Ref: D2013/113817

24 January 2014

Warehouse and Distribution Facilities, Oakdale Central (SSD 6078)

OLD WALLGROVE ROAD
(MC01) PLAN AND
LONGITUDINAL SECTION
SHEET 1

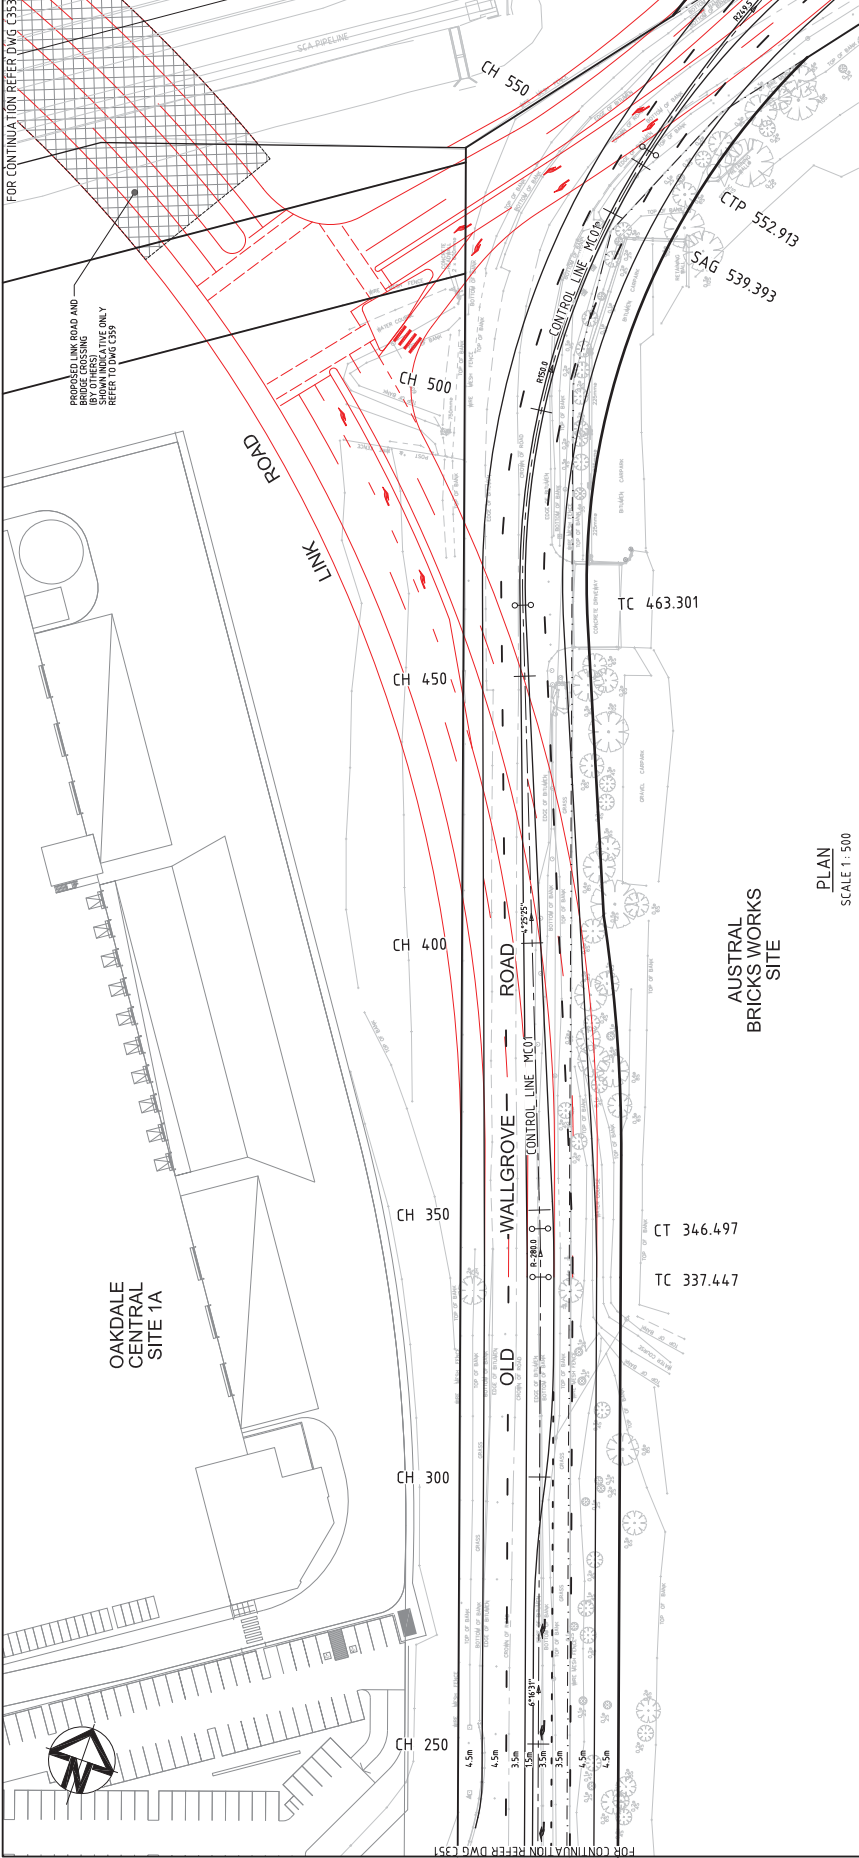
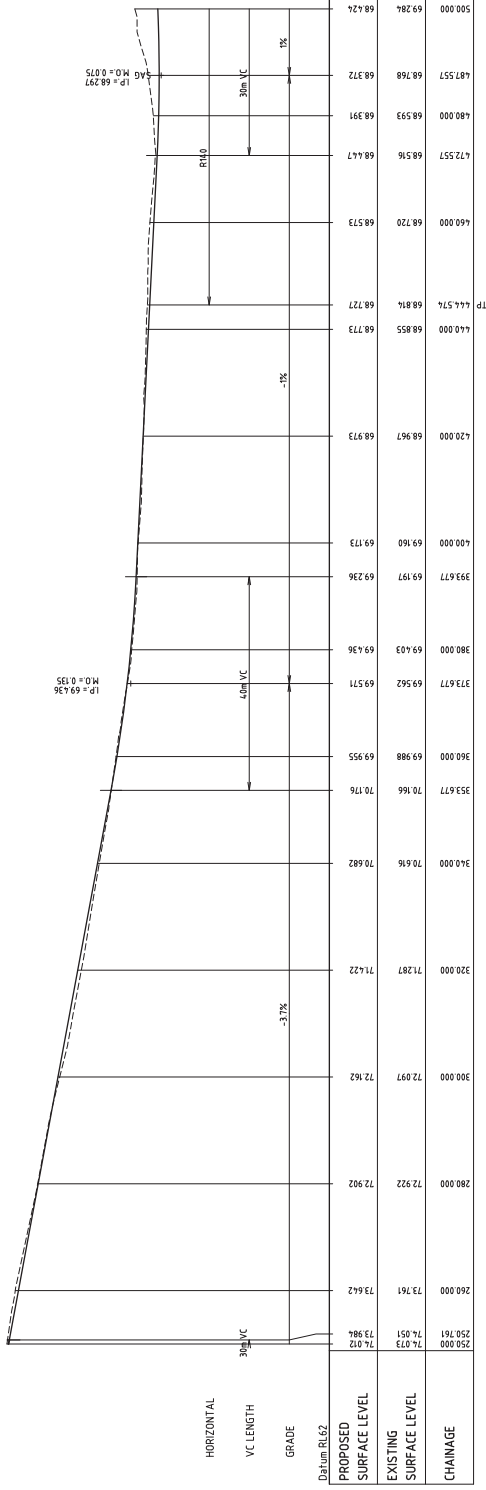
The SCA is particularly concerned with the design of the access points and driveways into the Pipelines corridor. SCA operational vehicles and contractors traverse the length of the corridor, in both directions, on a daily basis. This means vehicles regularly cross Old Wallgrove Road, in both directions, going from one section of the Pipelines corridor to the other.

The SCA is concerned that neither of the most recent plans provided by AT&L on behalf of Goodman (Drawing C354 dated 21-10-2013) or AECOM on behalf of the Department (60301100-03B-FIG-ST-0007) appears to allow vehicles to safely cross Old Wallgrove Road. The SCA requests the Department undertake a road safety assessment in relation to SCA access to ensure the final design for the road upgrade provides safe access to SCA land and safe vehicle crossing over Old Wallgrove Road.
